City of Portland, Maine - Building or Use Permit

Permit No: 2013-00698	Date Applied For: 04/10/2013	CBL: 156 E006001
---------------------------------	--	----------------------------

Proposed Use: Single Family	Proposed Project Description: Build a new deck - 18' x 12' & 8' x 5'
---------------------------------------	--

Machado Builders
Adams Deck
11 WELLSWOOD RD

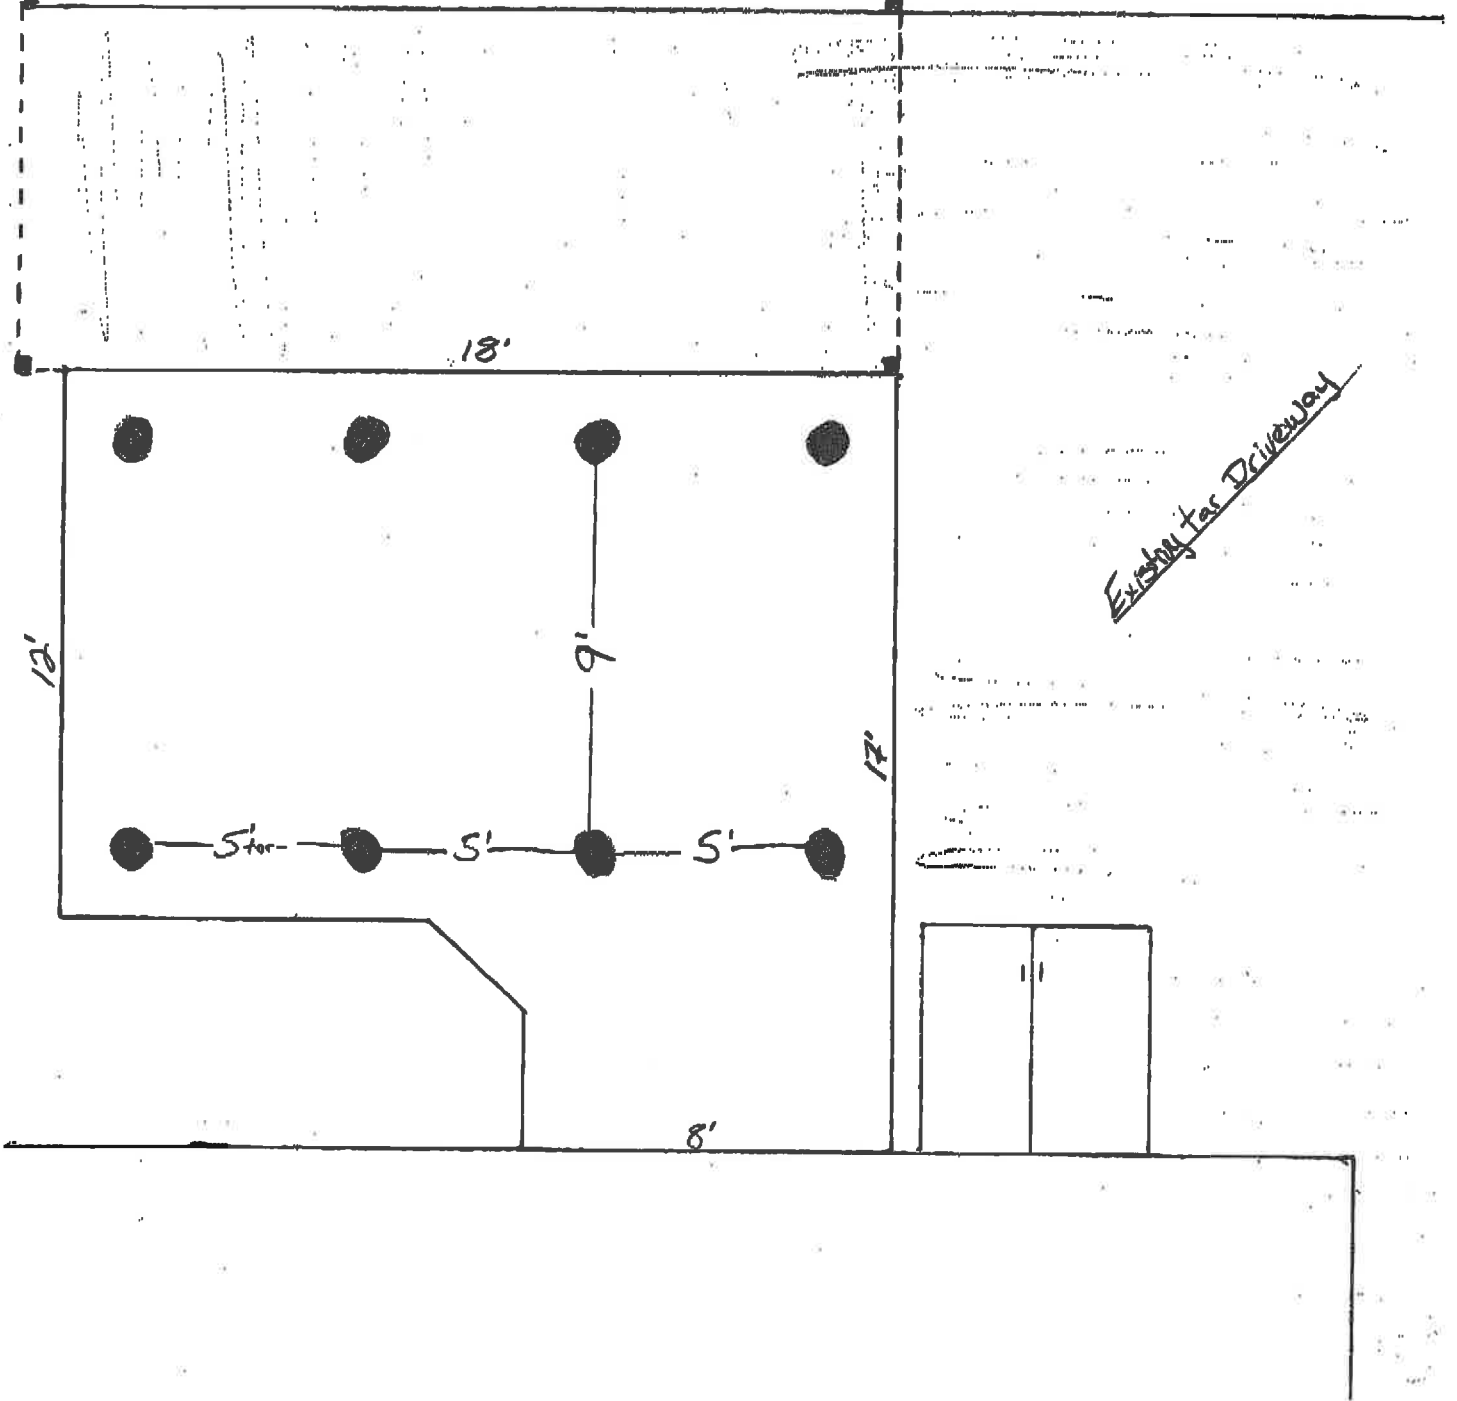
- 1) Deck ledger connection to band joist shall comply with R502.2.2.1
For decks with cantilevered framing members, connections to exterior walls or other framing members, shall be designed and constructed to resist uplift resulting from the full live load specified inTableR301.5 acting on the cantilevered portion of the deck.

- 2) R502.6 Bearing. The ends of each joist, beam or girder shall have not less than 1.5 inches of bearing on wood or metal and not less than 3 inches on masonry or concrete except where supported on a 1-inch-by-4-inch ribbon strip and nailed to the adjacent stud or by the use of approved joist hangers.

- 3) R312.3 Opening limitations. Required guards shall not have openings from the walking surface to the required guard height which allow passage of a sphere 4 inches in diameter.

- 4) A graspable handrail (34-38 inches in height) shall be provided on at least one side of each continuous run of treads or flight with four or more risers. Fall protection (36 inches) from exterior decks may be required if floor joist are at or above thirty (30) inches from grade.

- 5) Section R317 Protection of Wood and Wood Based Products against decay. All wood framing members that rest on concrete or masonry exterior foundation walls and are less than 8 inches from the exposed ground.

11 Wellwood Road
Portland, Maine

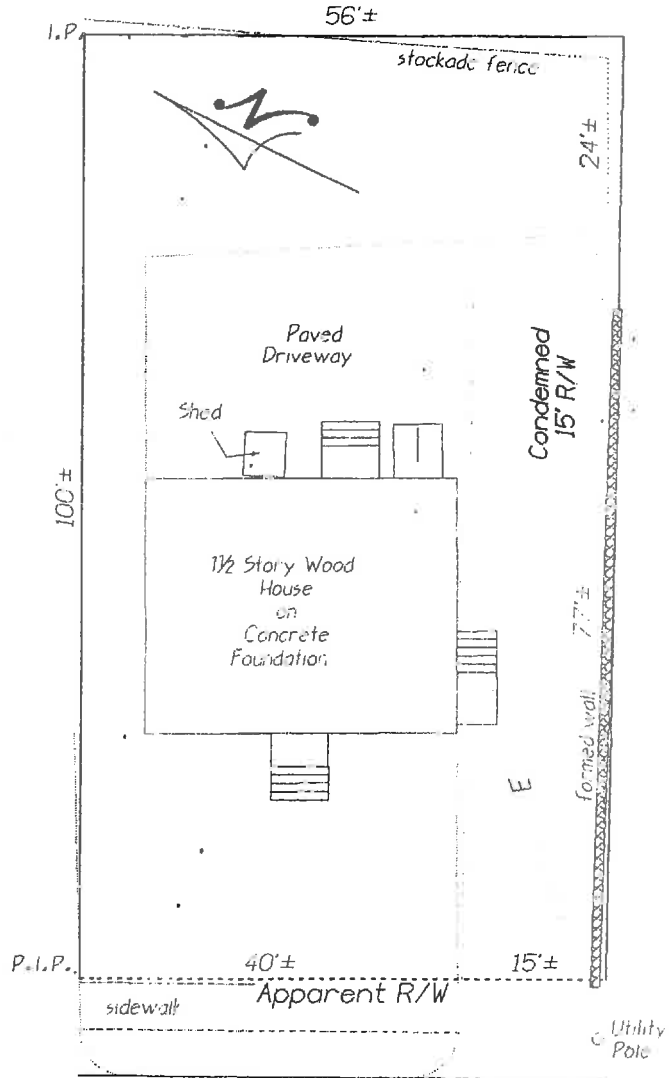
rear - 25' min -31' given, 30 scaled OK
side 8' min - 23' on right OK; 20' given but scales at 13'on left - OK
lot coverage = 1943.9 sf - 852 + 256 = 1108 sf OK
